WEST SUSSEX COUNTY COUNCIL CONSULTATION

TO:	Arun District Council FAO: S Davis
FROM:	WSCC - Highways Authority
DATE:	4 July 2019
LOCATION:	Chandlers Garage Bmw House Water Lane Littlehampton BN16 4EH
SUBJECT:	A/45/19/PL Demolition of existing buildings (car show room, workshops and Phares Courtledge) and erection of 19 dwellings, a convenience store, a community building, public toilets and associated car parking and landscaping - This application affects the character and appearance of the Angmering Conservation Area. More information.
DATE OF SITE VISIT:	
RECOMMENDATION:	No Objection
S106 CONTRIBUTION TOTAL:	£ 97,006

Scale	1:250	Drawn By	SMO	Checked By	ALB	Approved By	PMR
Date	March 2019	Drawing No	2018-4619-002	Rev.			B

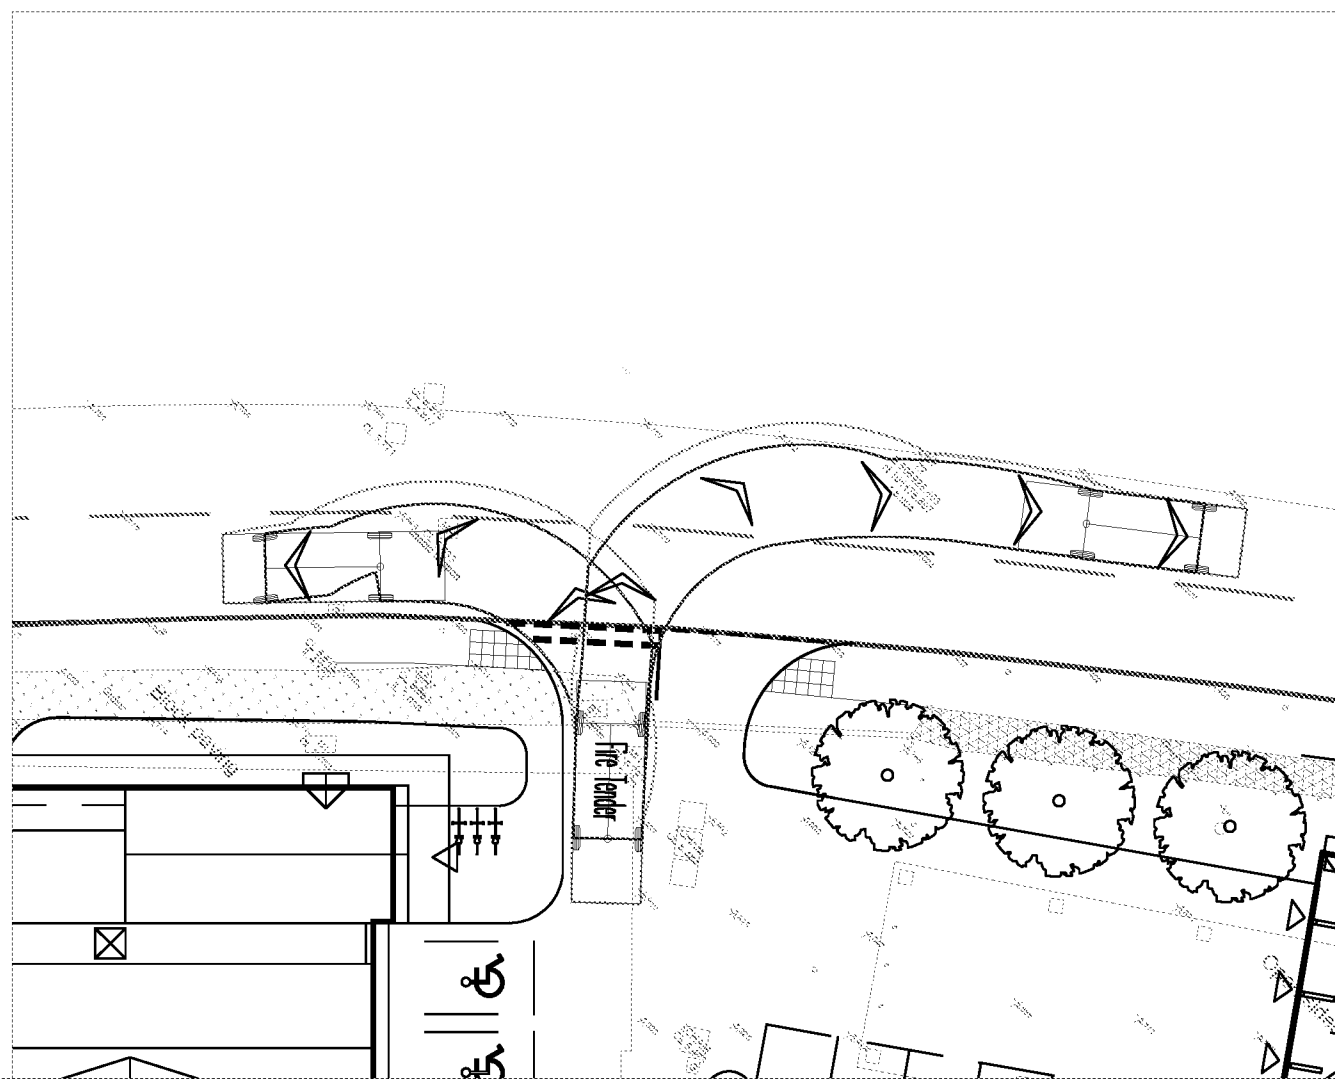
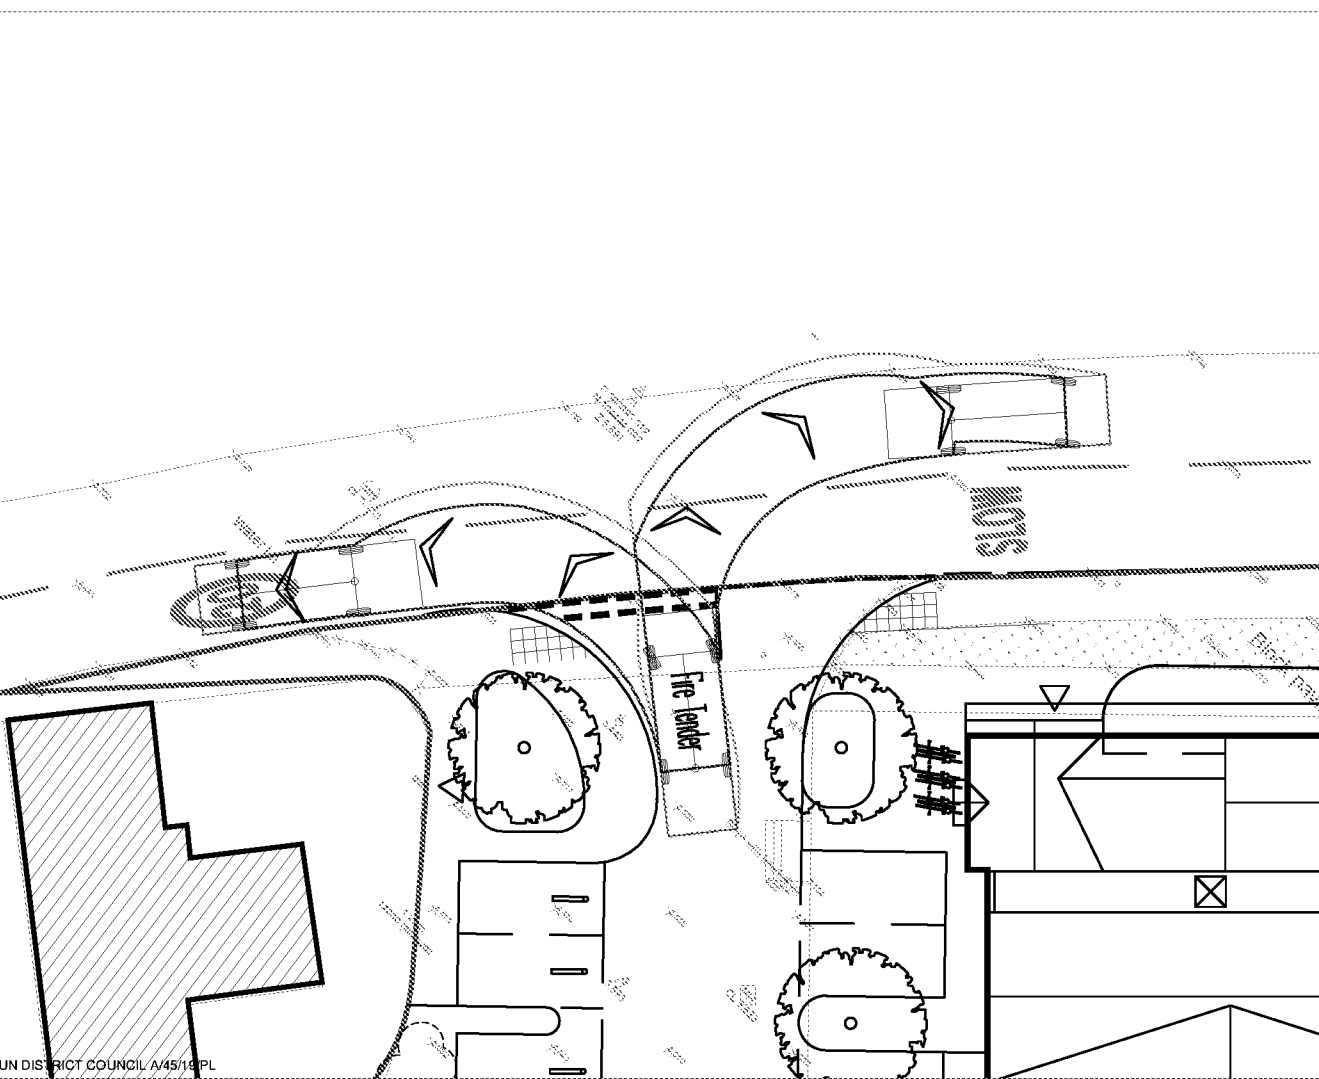
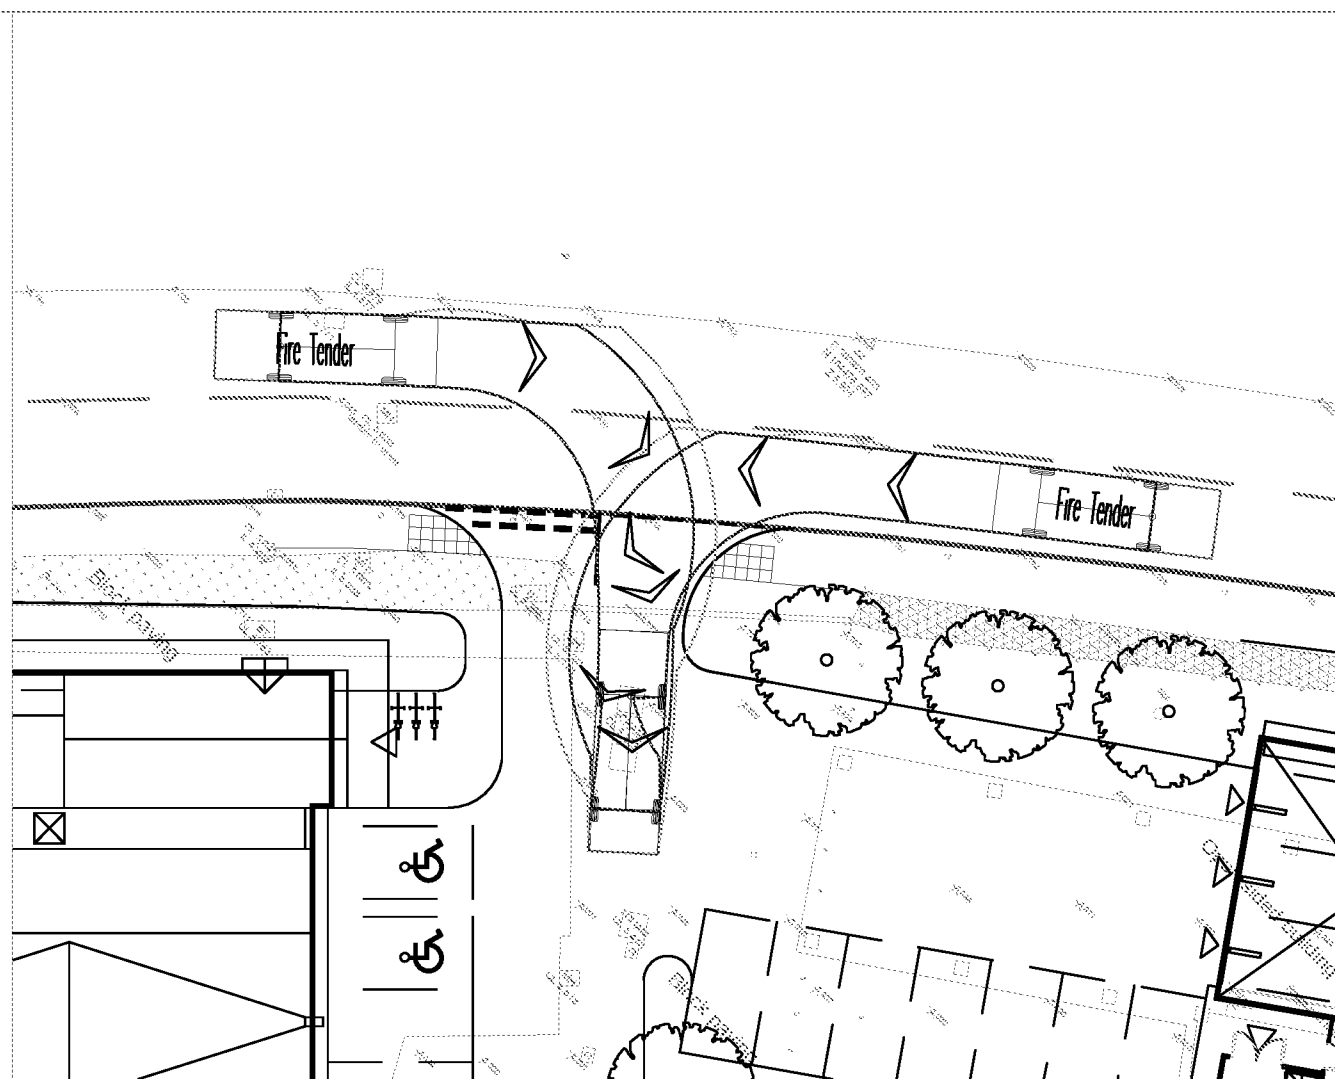
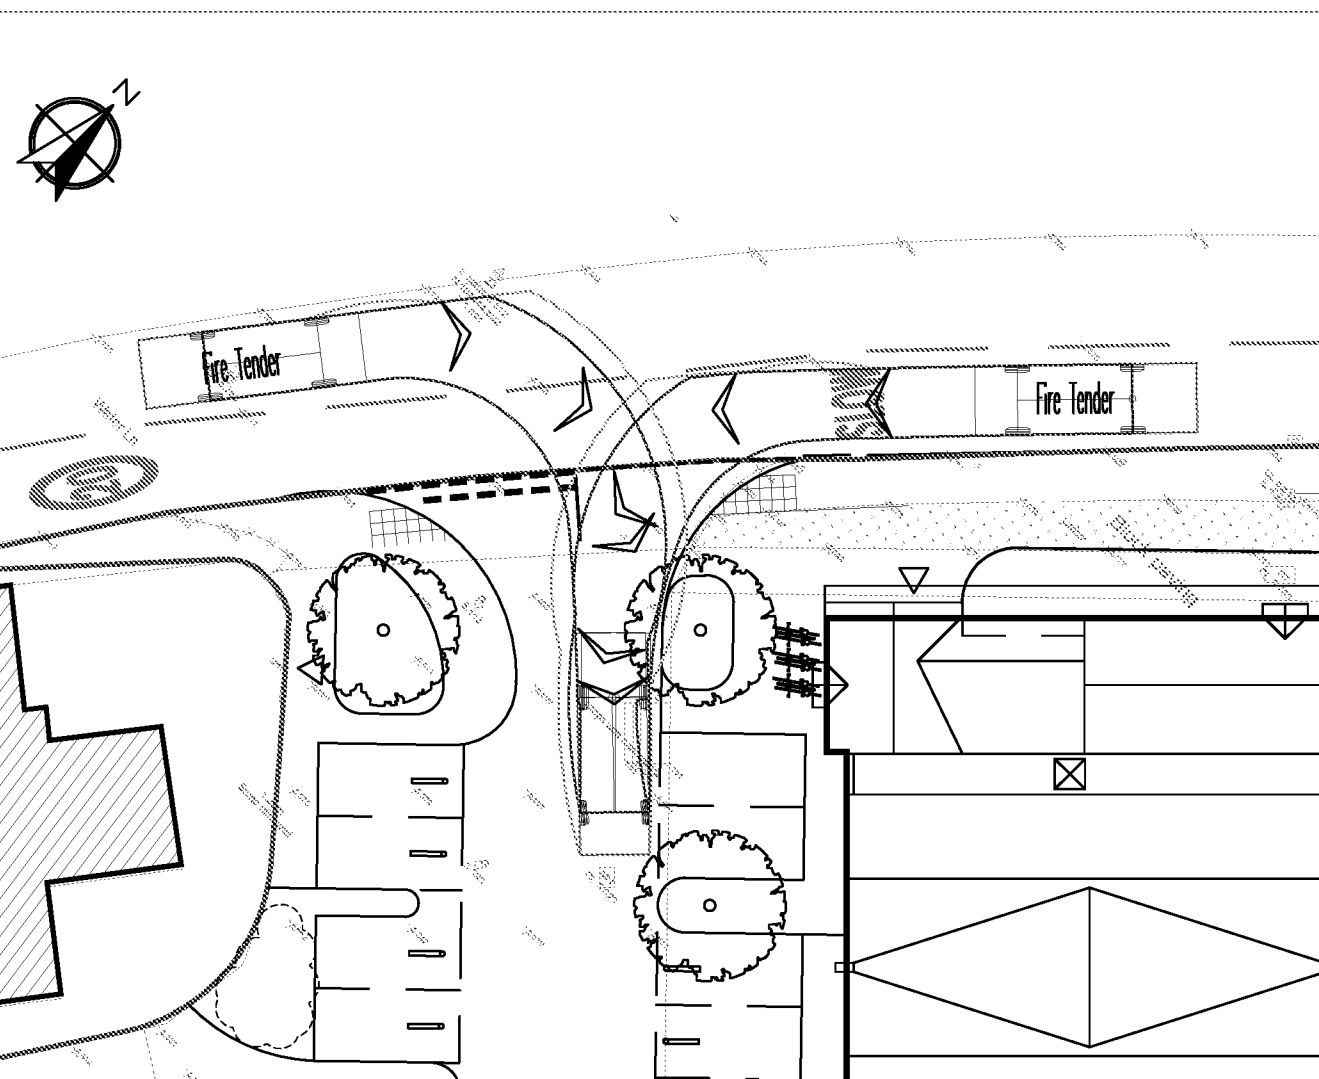
The parking allocation is in accordance with the demand from the WSCC PDC (Parking Demand Calculator). From checking this and based on the proposed mix and tenure of the dwellings, the car parking provision is anticipated to satisfy the likely demands. Swept path diagrams have been provided which outline the ability for a vehicle to turn within the site to egress in a forward gear onto Water Lane.

The eastern access has demonstrated that the refuse vehicles would have sufficient space to enter the site, the plan however does not outline the dimensions of the vehicle used for this diagram, I can advise that Arun District Council use 26T Mercedes Econic 6x2 rear steer Refuse Collection Vehicles. The same type of vehicle is used for both refuse and recycling. Garden waste is collected by a 26t Dennis Elite 6x2 rear steer collection vehicle.

There would appear sufficient space for these types of vehicles, however I advise that the applicant liaises with the relevant collection authorities to ensure this is considered an acceptable arrangement.

Problems Location Plan

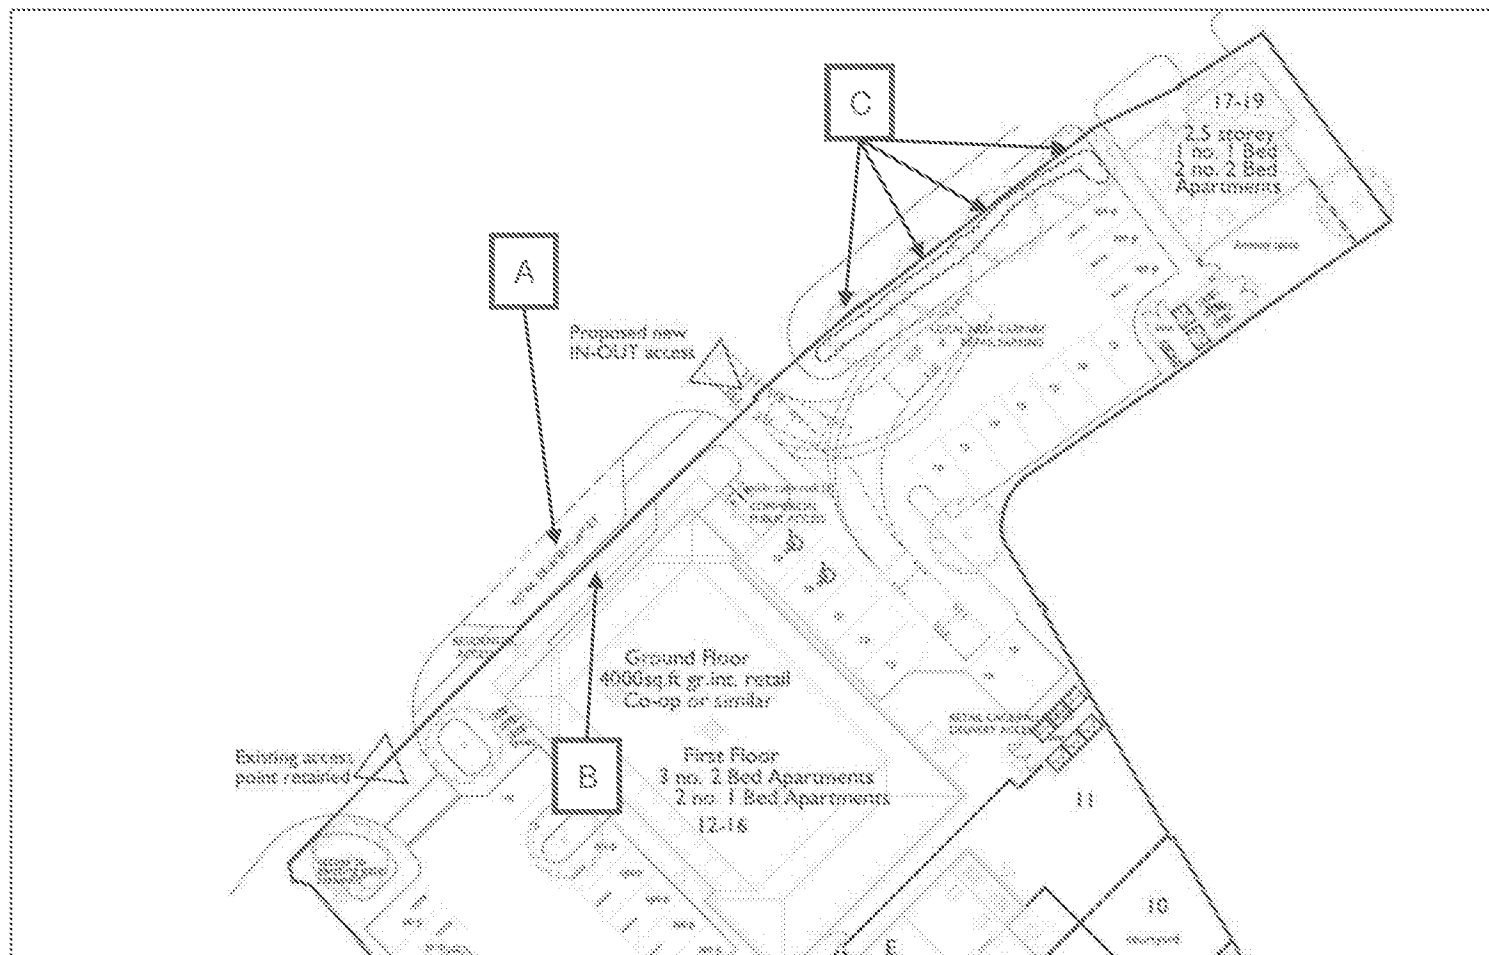
Lay-by between the two accesses- Risk of side swipe (pull out) collisions at the vehicular accesses

The lay-by is to be provided to facilitate retail loading and unloading by service vehicles. A lorry or van parked in this lay-by will obstruct the visibility splays from each of the vehicular accesses to the development, increasing the risk of side swipe collisions as vehicles exit the development. Whilst the probability of such collisions is low, as the loading and unloading will only take place for short periods of time each day, the risk will increase if general parking by residents takes place in it throughout the day.

The lay-by should be relocated outside of visibility splays from the vehicular accesses. If this is not possible it should be designated as a loading bay only and an appropriate traffic order imposed on it accordingly.

Lay-by between the two vehicular accesses- risk of pedestrian/vehicular collisions

When a delivery vehicle is unloading to the retail unit, the footway adjacent to the lay by may be of insufficient width to allow goods to be unloaded whilst pedestrians are passing. Pedestrians may, therefore, walk on the carriageway side of the delivery vehicle, risking collisions with south-westbound through traffic.

The footway adjacent to the lay-by should be of sufficient width for the passage of pedestrians, including wheelchair users and double buggies, whilst a delivery vehicle is unloading to serve the retail unit.

Planting along the north eastern end of the frontage onto Water Lane- risk of side swipe collisions at the north eastern vehicular access

The architect's sketch layout shows trees to the north-east of the wider vehicular access, their crowns over-hanging the footway. Depending on the type of tree, the crowns may bush out over time, obstructing visibility for the driver of goods vehicles exiting this access, consequently increasing the risk of side swipe collisions with vehicles approaching from the north east.

The trees planted along the north-eastern end of the frontage onto Water Lane should be of a variety that does not encroach over the highway over time.

This point was agreed and the lay-by removed by the design team

This point was agreed and the lay-by removed by the design team

This point was agreed and the design team propose a variety of tree that does not encroach on visibility splays and over the highway over time.
